Current Zoning: N1-A (Neighborhood 1-A)  
Proposed Zoning: B-1 (CD) (Neighborhood Business, Conditional)

Approximately 3.99 acres located at the intersection of Rhyne Road and Moores Chapel Road.

The petition proposes to develop a vacant property in northwest Charlotte with up to 10,000 square feet of uses permitted in the B-1 zoning district including 16 fuel pumps and a fast food restaurant with drive-through.

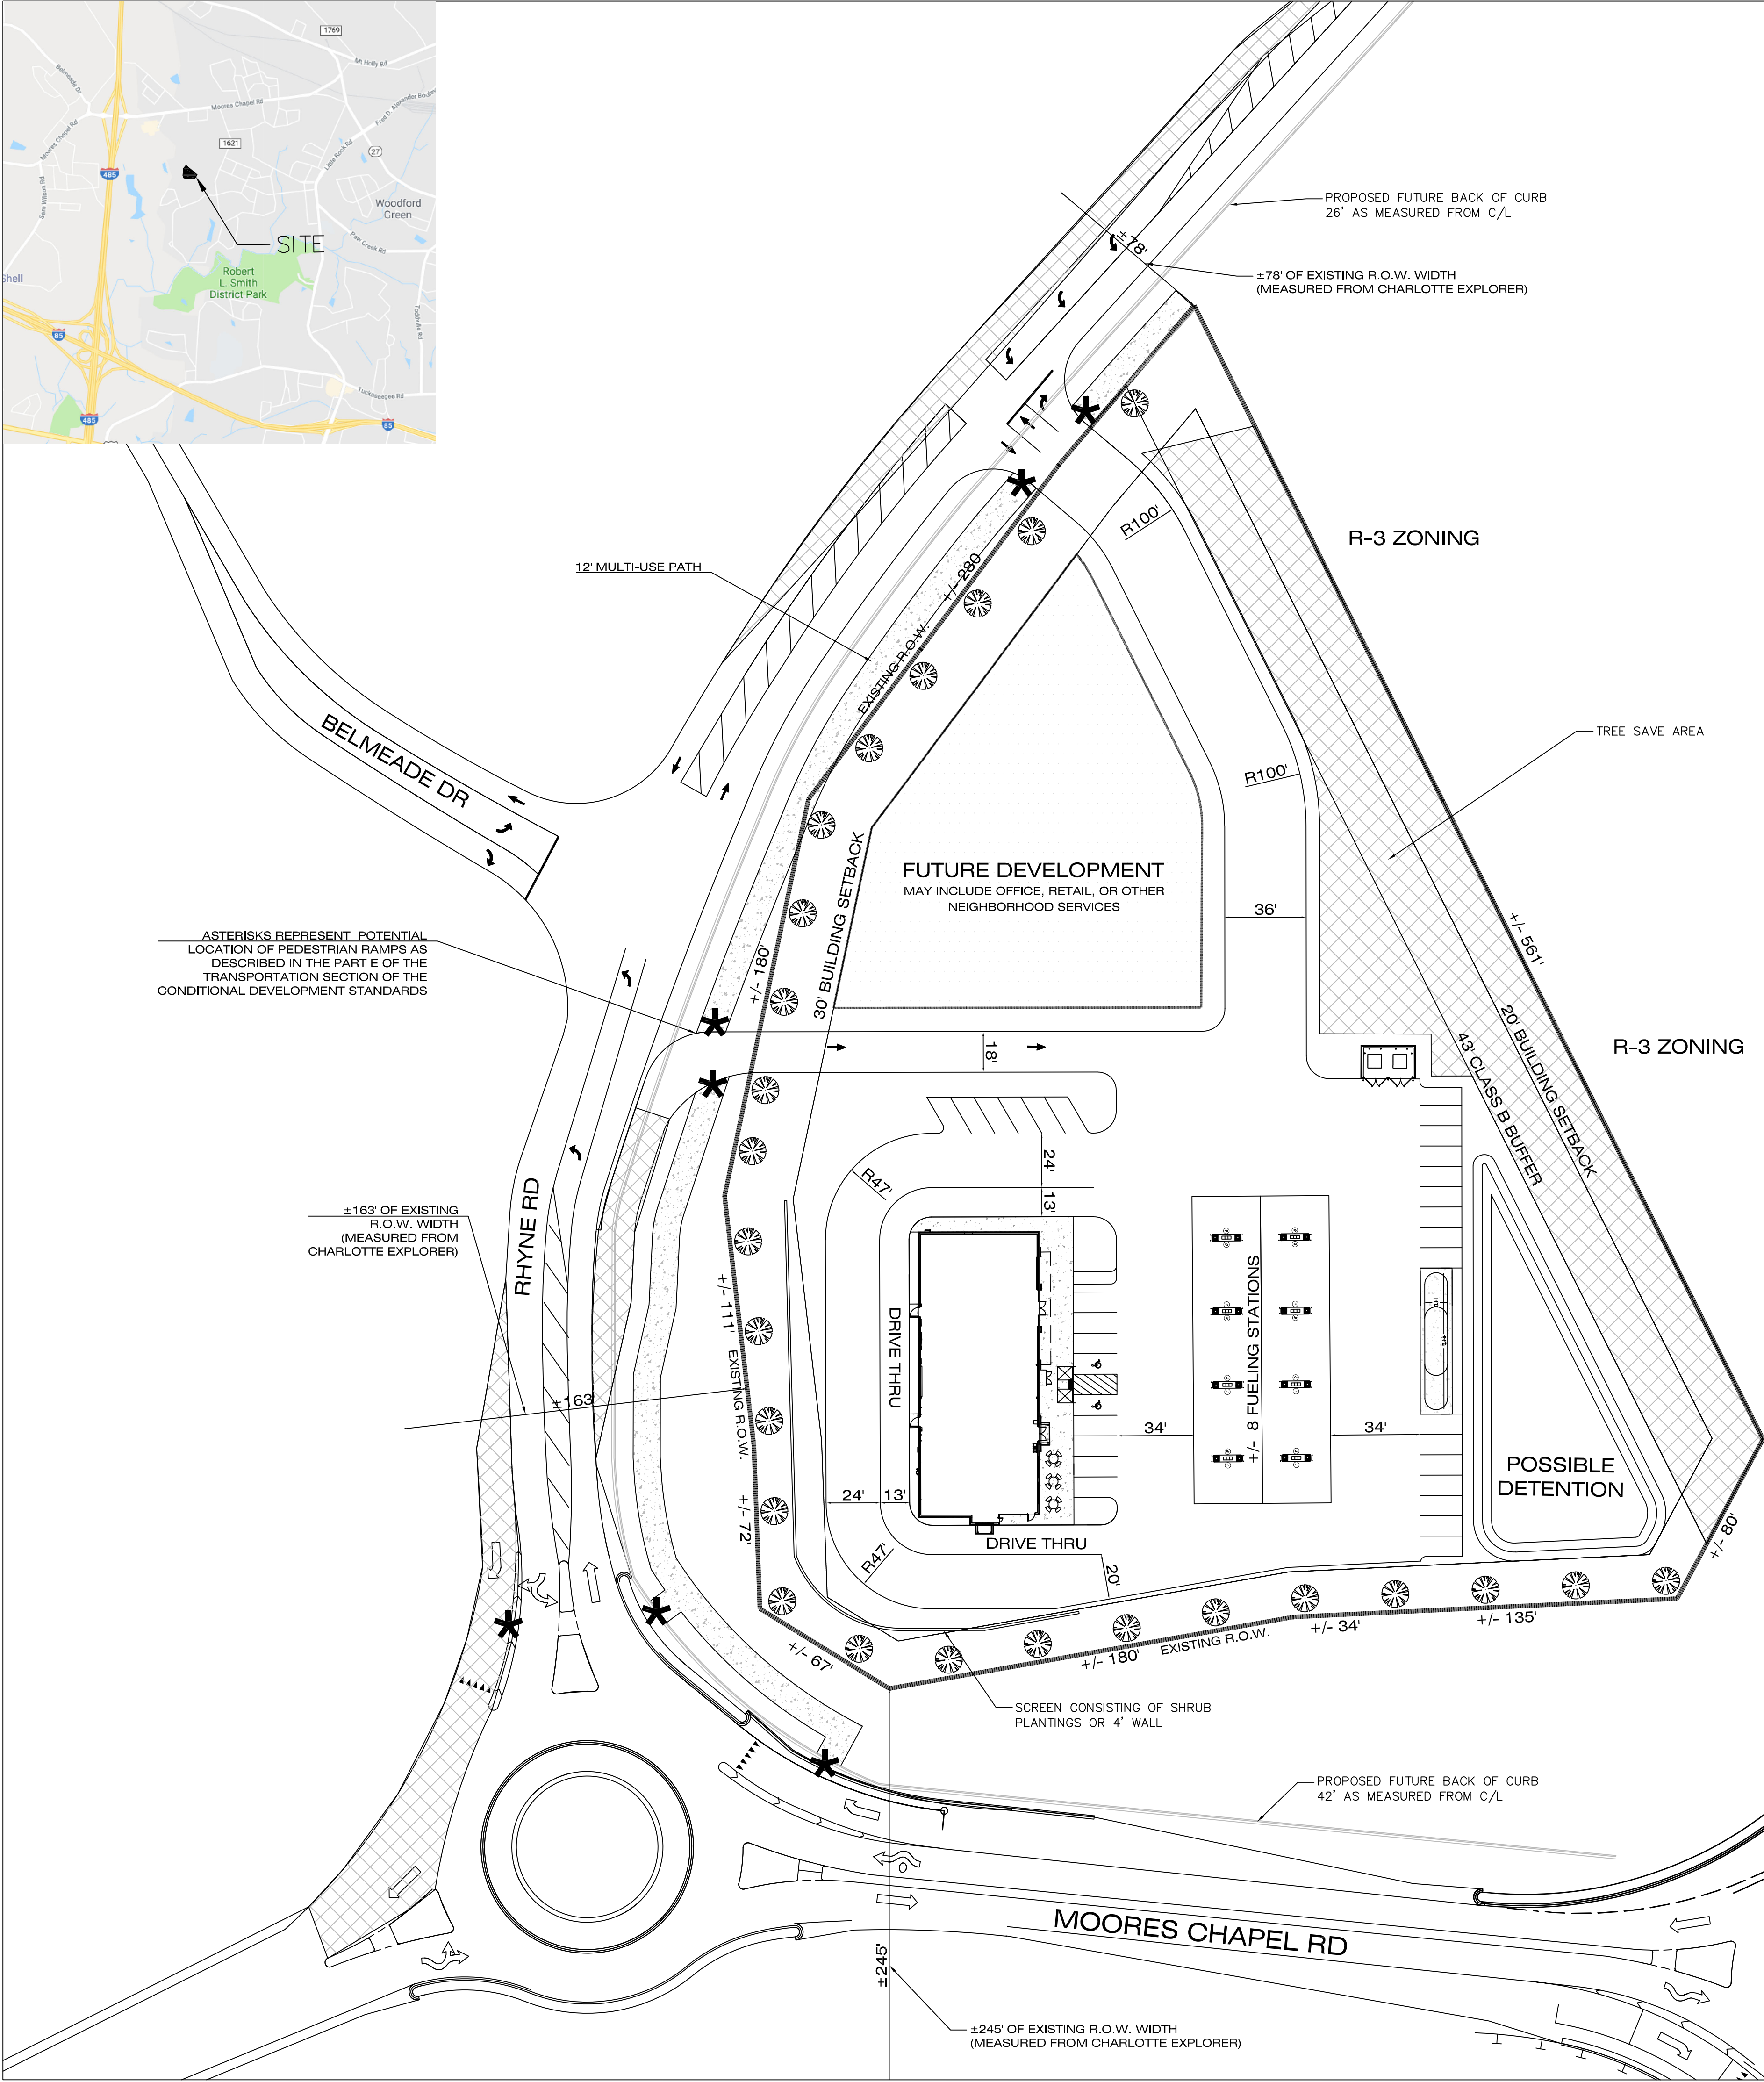
1. Revise site plan and conditional note(s) to provide 12-foot multi-use path and 8-foot planting strip along all public road frontages (Moores Chapel Road, Rhyne Road, Belmeade Drive). Revise the ramp locations and conditional note Transportation Note E to include the additional ramps that will be required. Provide SUE located 2-feet behind sidewalk if located outside of the ROW. Add conditional note to coordinate Control of Access Break with NCDOT for proposed multi-use path along Moores Chapel Road.

2. Label and dimension streetscape along all public road frontages (12-foot multi-use path and 8-foot planting strip). Revise ramp locations as shown above and update conditional note to incorporate additional ramps. Provide SUE located 2-feet behind sidewalk if located outside of the ROW. Add conditional note to coordinate Control of Access Break with NCDOT for proposed multi-use path along Moores Chapel Road.

3. Label, dimension, and commit to curb and gutter and multi-use path in conditional notes.
4. Add a conditional note specifying that all transportation improvements will be approved and constructed before the site's first building certificate of occupancy is issued as needed. The petitioner may phase transportation improvements if said improvements and phasing are explicitly described in site plan notes.

6. Remove "Convert the southbound right turn lane to a free flow right" as its mentioned twice. Then add the following to the first sentence for the Moores Chapel at I-485 SB Off-Ramp intersection "Convert the southbound right turn lane to a free-flow right with channelization island." (See CDOT Memo 04-09-24)
7. Rhyne Rd At Belmeade – remove note regarding construction of an eastbound left turn lane on Belmeade with 150' of storage plus taper as [itsit's](#) already been constructed.

8. Remove the first sentence of Transportation note b. Connections between buildings and the public sidewalk are required by ordinance.
  9. Revise Streetscape and Landscaping Note a to commit to screening the drive-through to UDO standards.
-
